CITY OF ALBUQUERQUE

July 2nd, 2014

**Re: Chick-Fil-A on Eubank, Grading and Drainage Plan
Engineer's Stamp Date 6-27-14 (L21D045B)**

NOTES

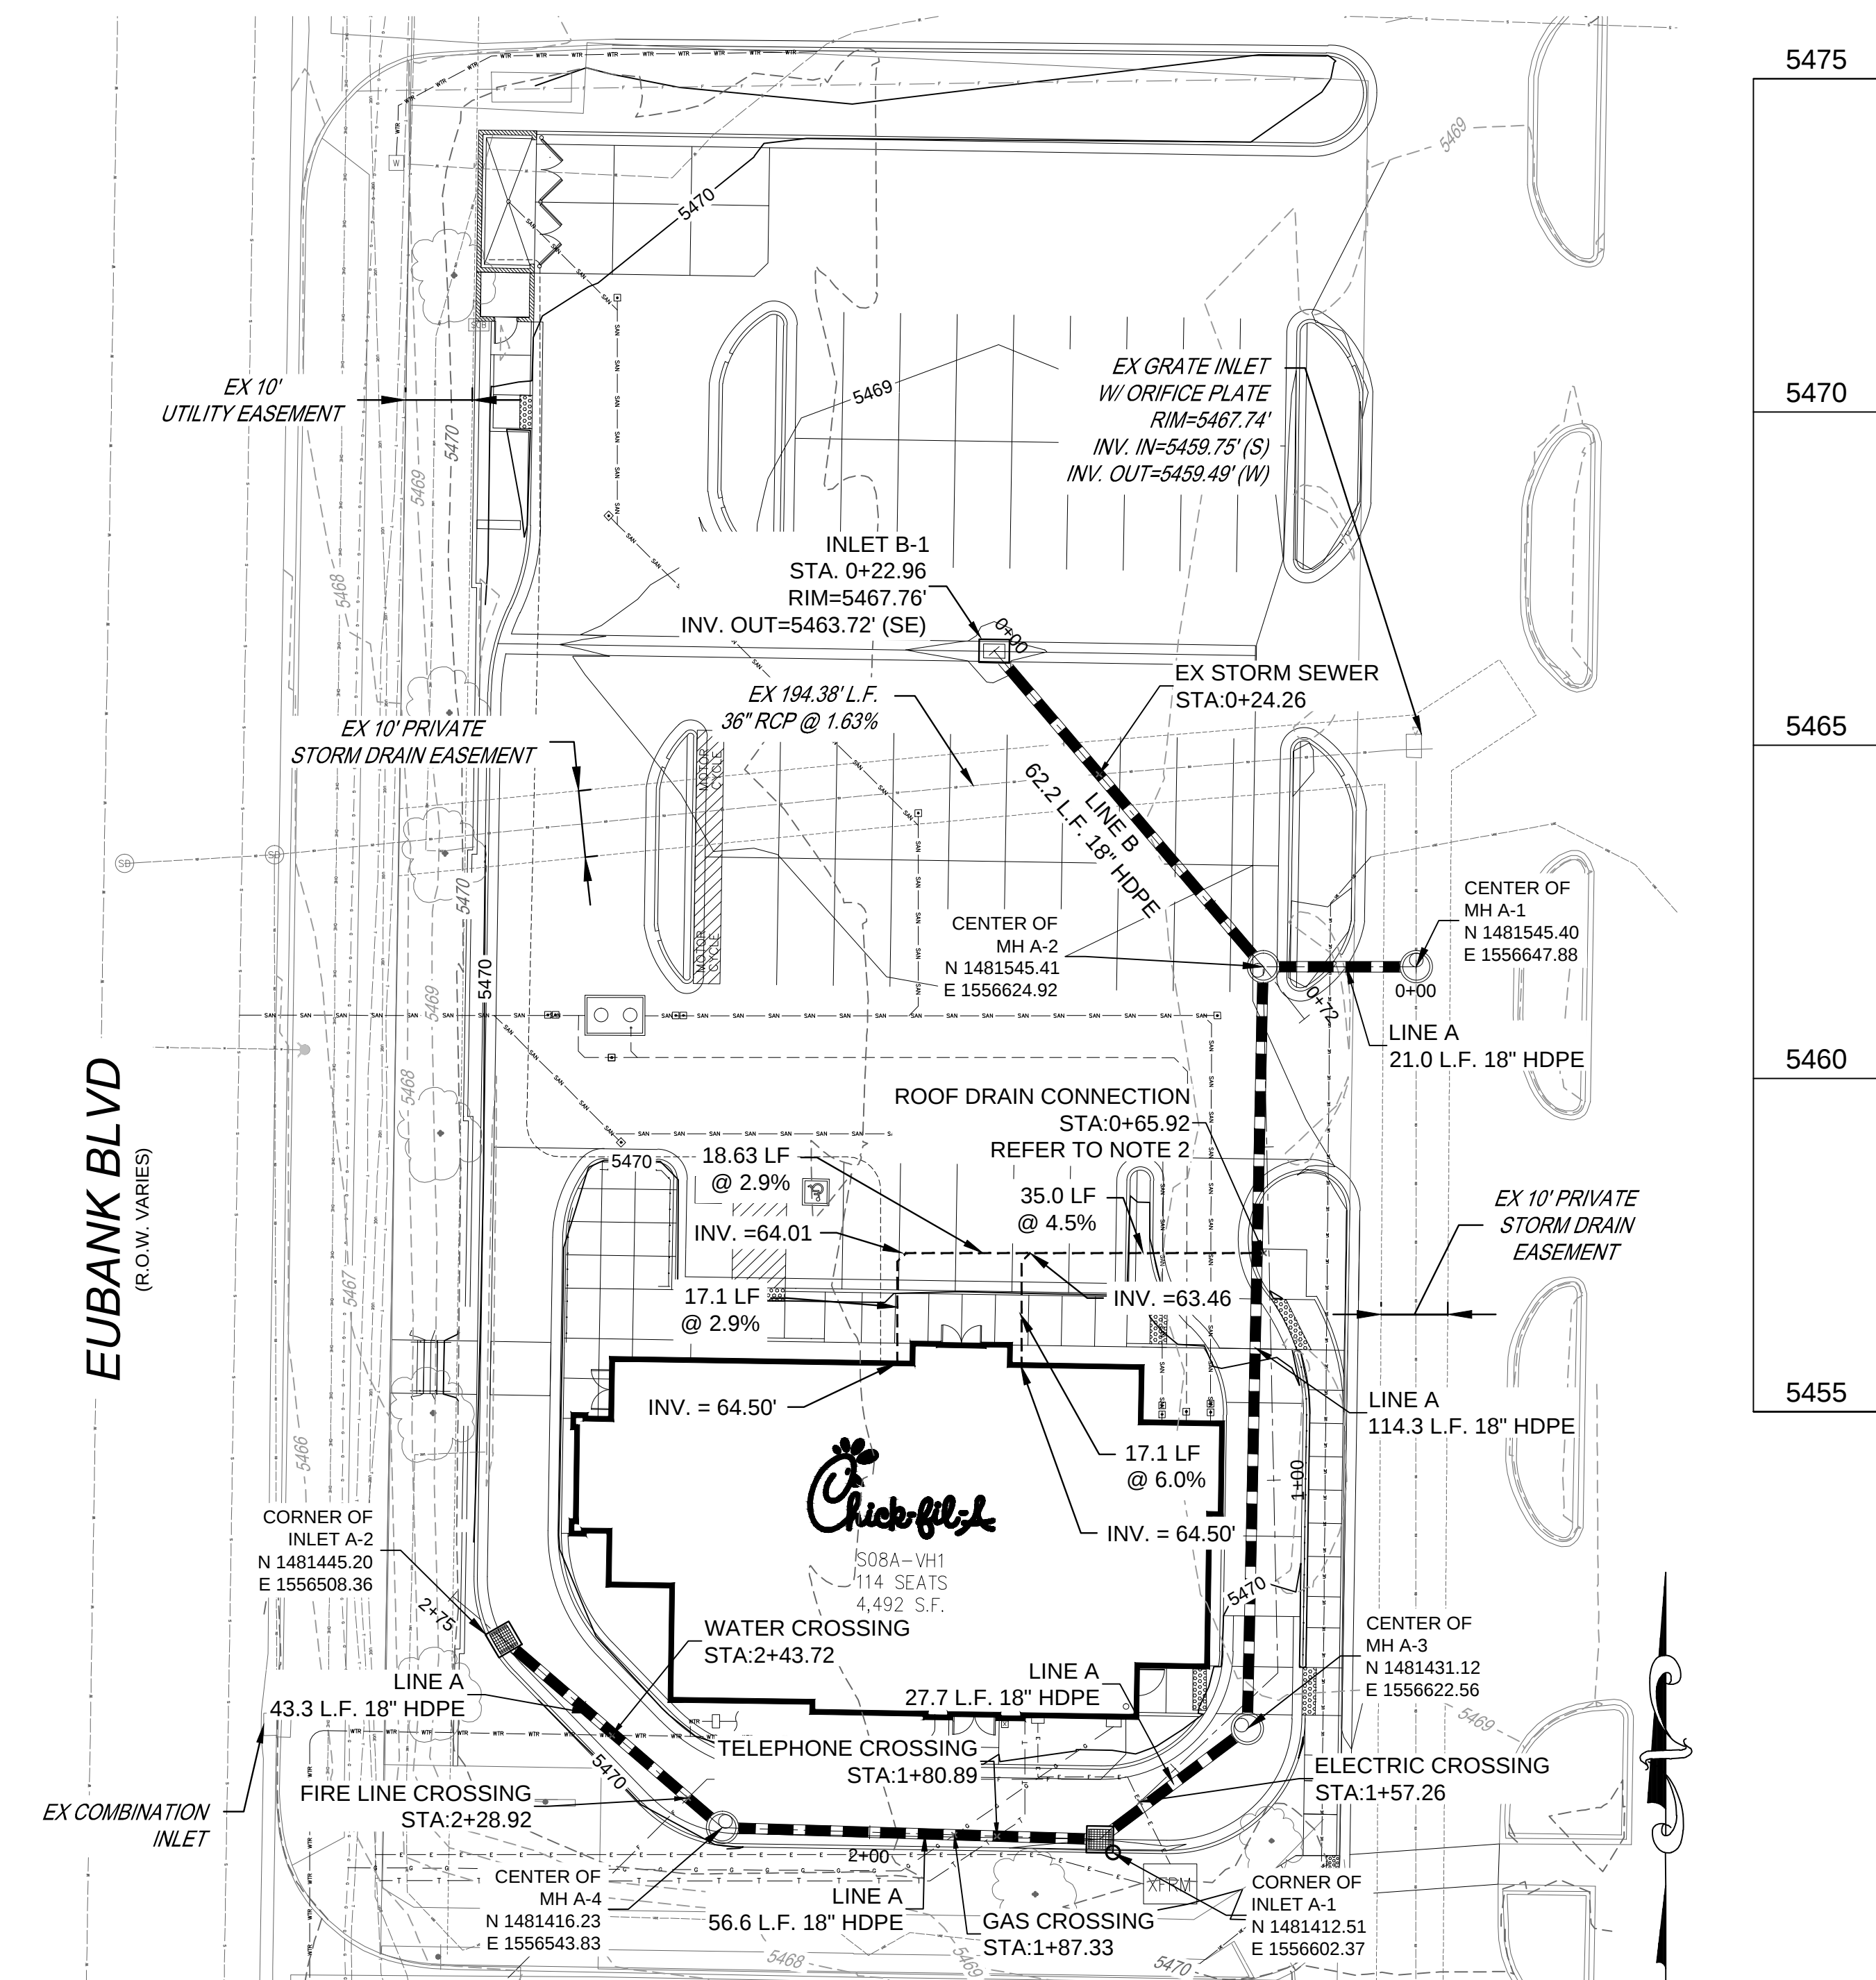
1. Include a Vicinity Map and either an image of the National Flood Insurance Map or a narrative on the flood zone status.
2. Is the proposed orifice plate required, since there is an orifice plate in the inlet that this system ties into?
3. Provide the direction of roof flows.
